Your ref:
Our ref: 21/01993/F
Please ask for: Mrs Rebecca Bush
Direct dial: 01553 616825
Direct fax: 01553 616652
E-mail: borough.planning@west-norfolk.gov.uk

Details: **Demolition of existing side extensions. Construction of 2 storey side extension and single storey front porch at Lumbertubs 7 Wheatley Drive North Wootton King's Lynn Norfolk**

PROJECT 7 WHEATLEY DRIVE, KING'S LYNN, NORFOLK, PE30 3QQ.	CLIENT MR & MRS EASEY	DWG No. 2106007-04	REVISION P5
DRAWING PROPOSED ELEVATIONS		DISCIPLINE PLANNING

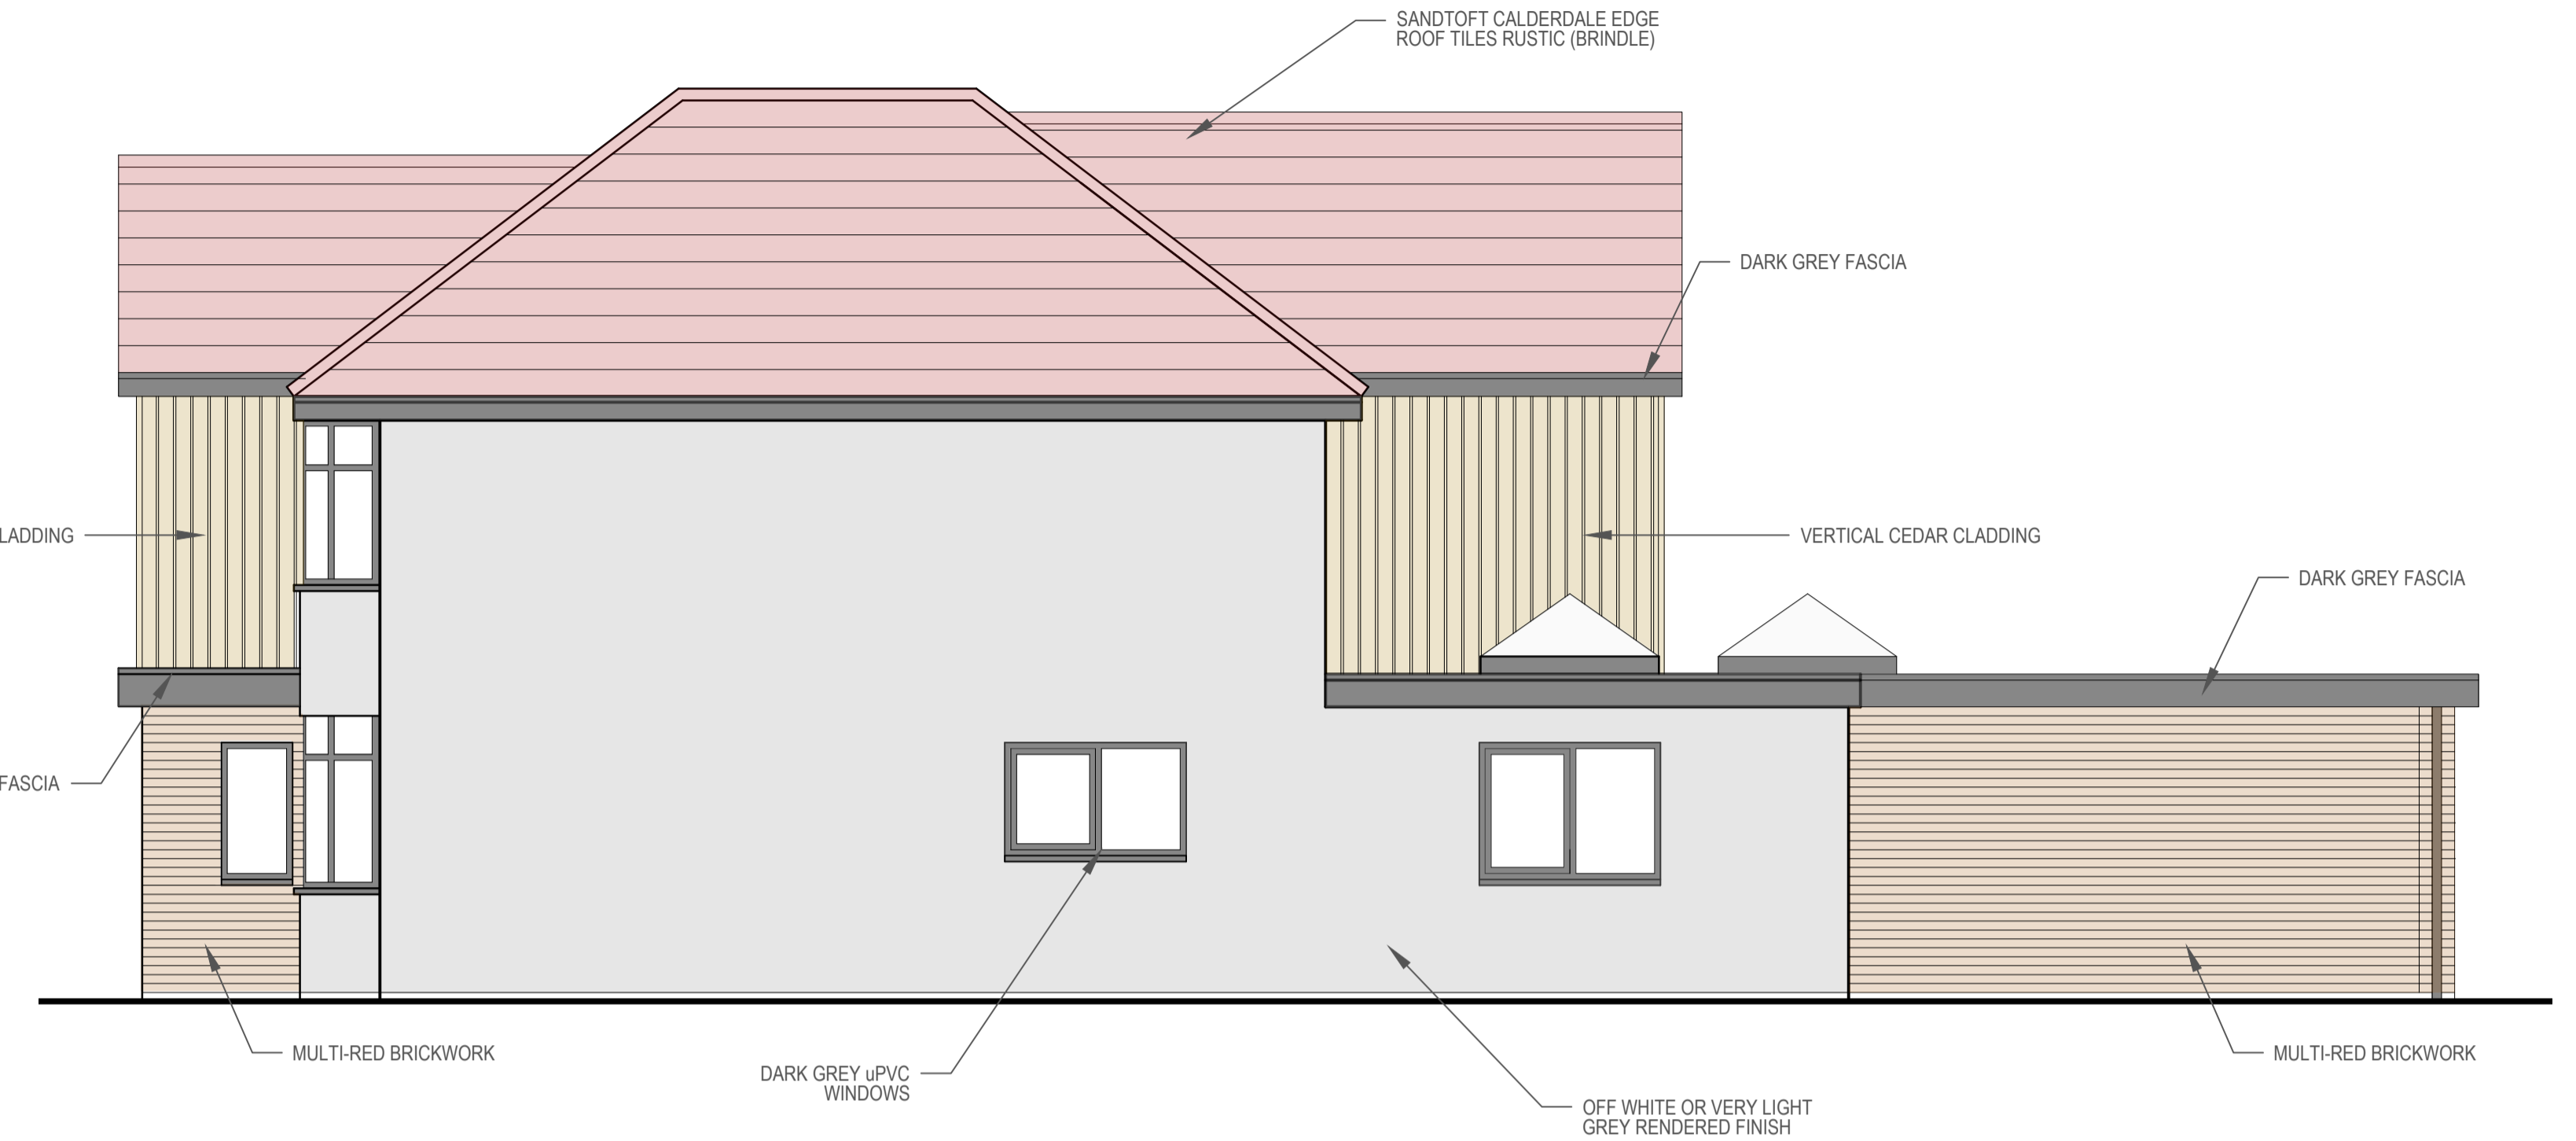
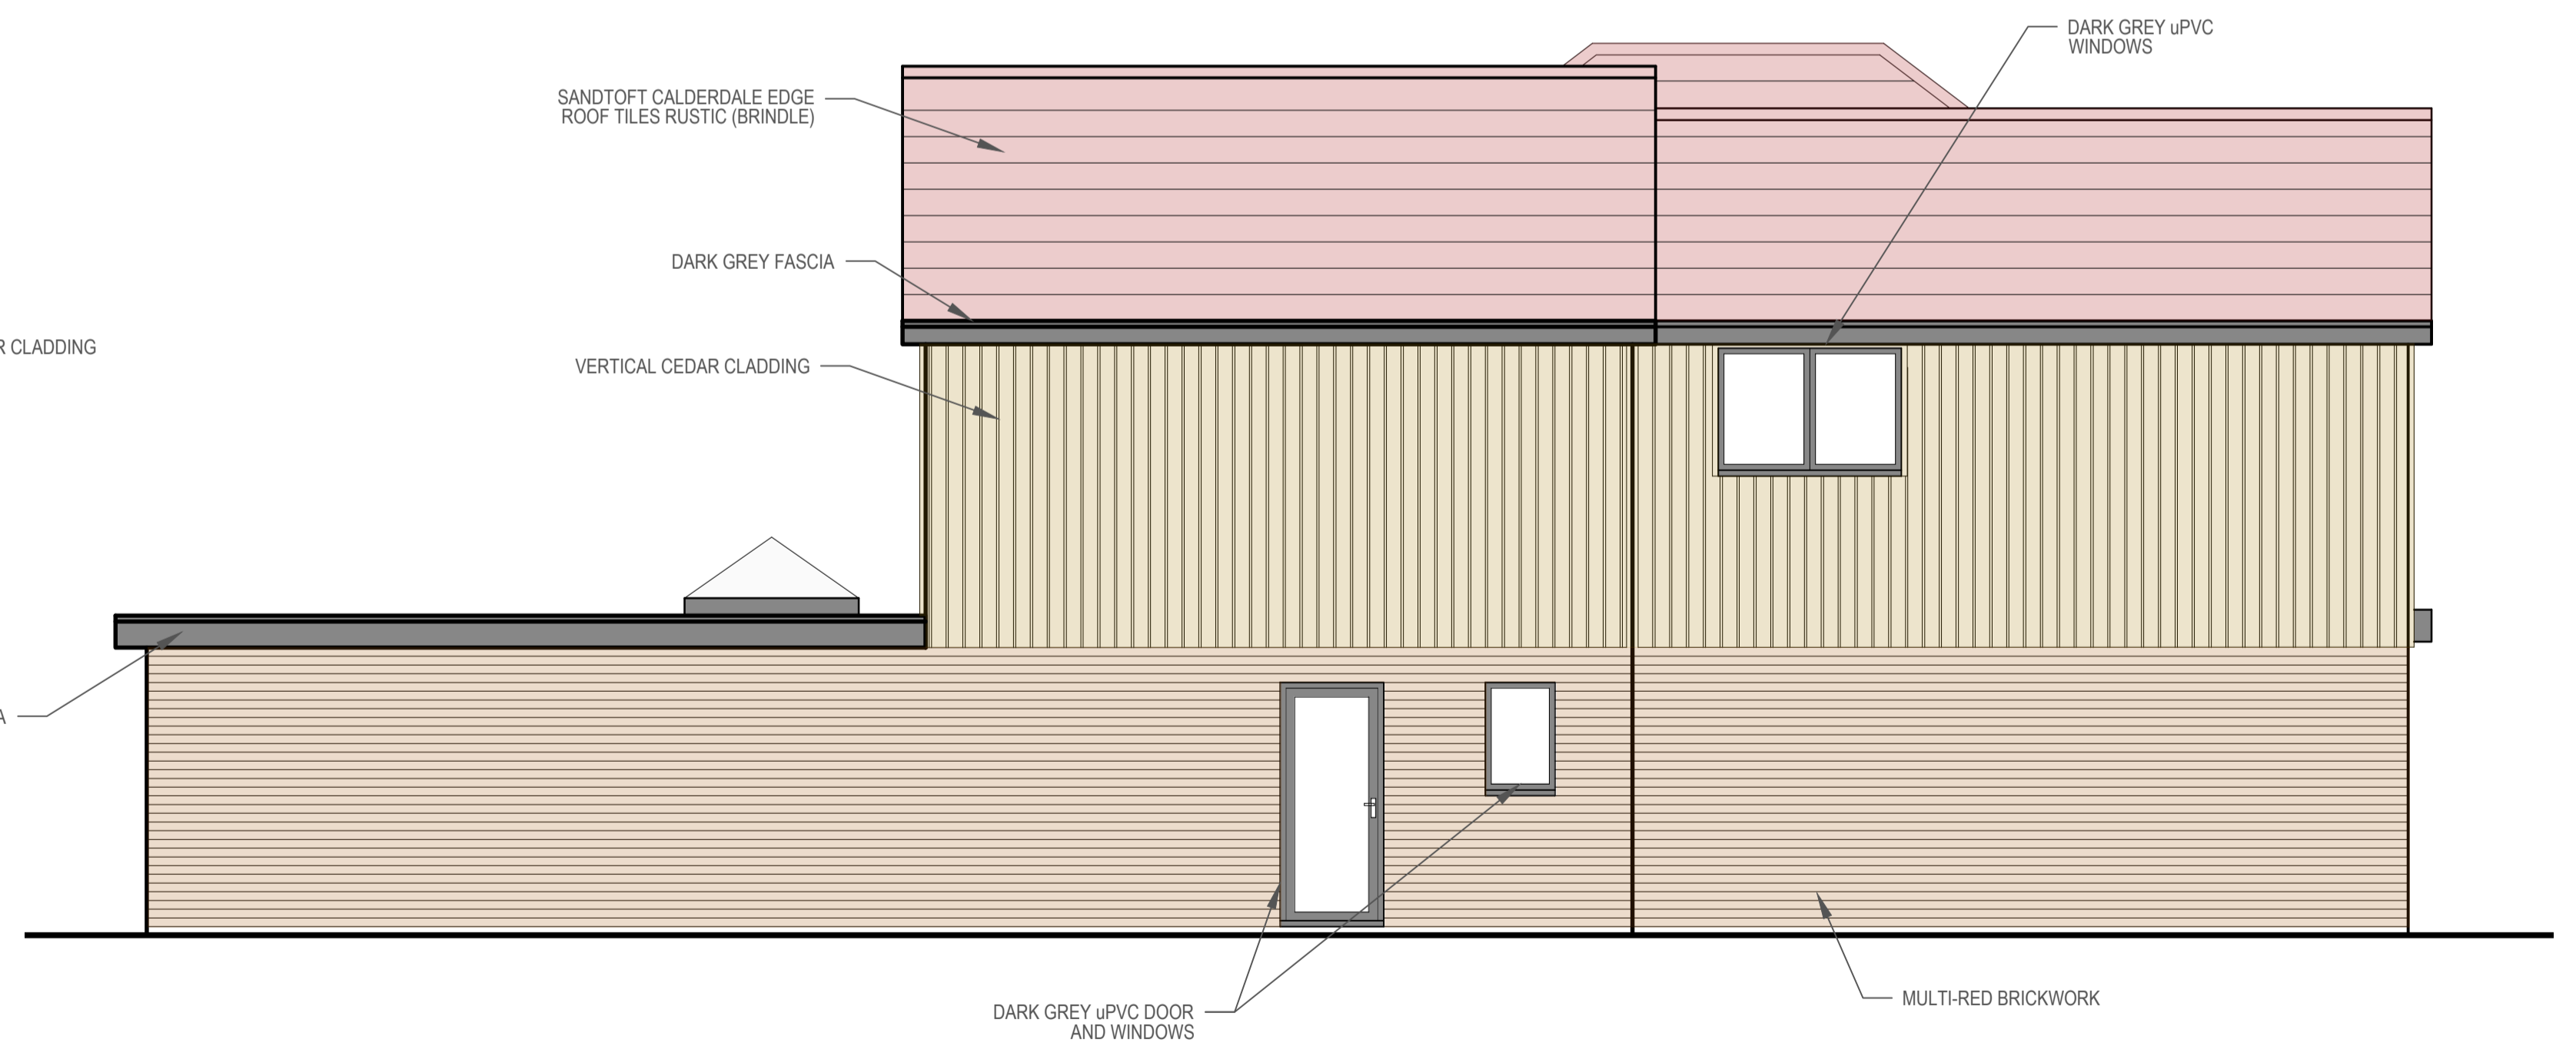
1. We will require a block plan/roof plan to a scale of 1:500 or 1:200 showing site boundaries and the new work.
2. Please provide four copies of a drawing, to a recognisable scale, showing a section through the new extension.
3. In accordance with the National Validation Checklist, which became mandatory on 6 May 2008, we will require information regarding site levels. If site levels are to change, please provide four copies of a site survey drawing, alternatively, if site levels are to remain unchanged, this can be annotated on the relevant plan or advised in writing.
4. As the property lies within an area at risk to flooding, please complete the simplified Matrix and return it. The Matrix can be found at https://www.west-norfolk.gov.uk/info/20173/information_for_planning_agents/231/flood_risk_information
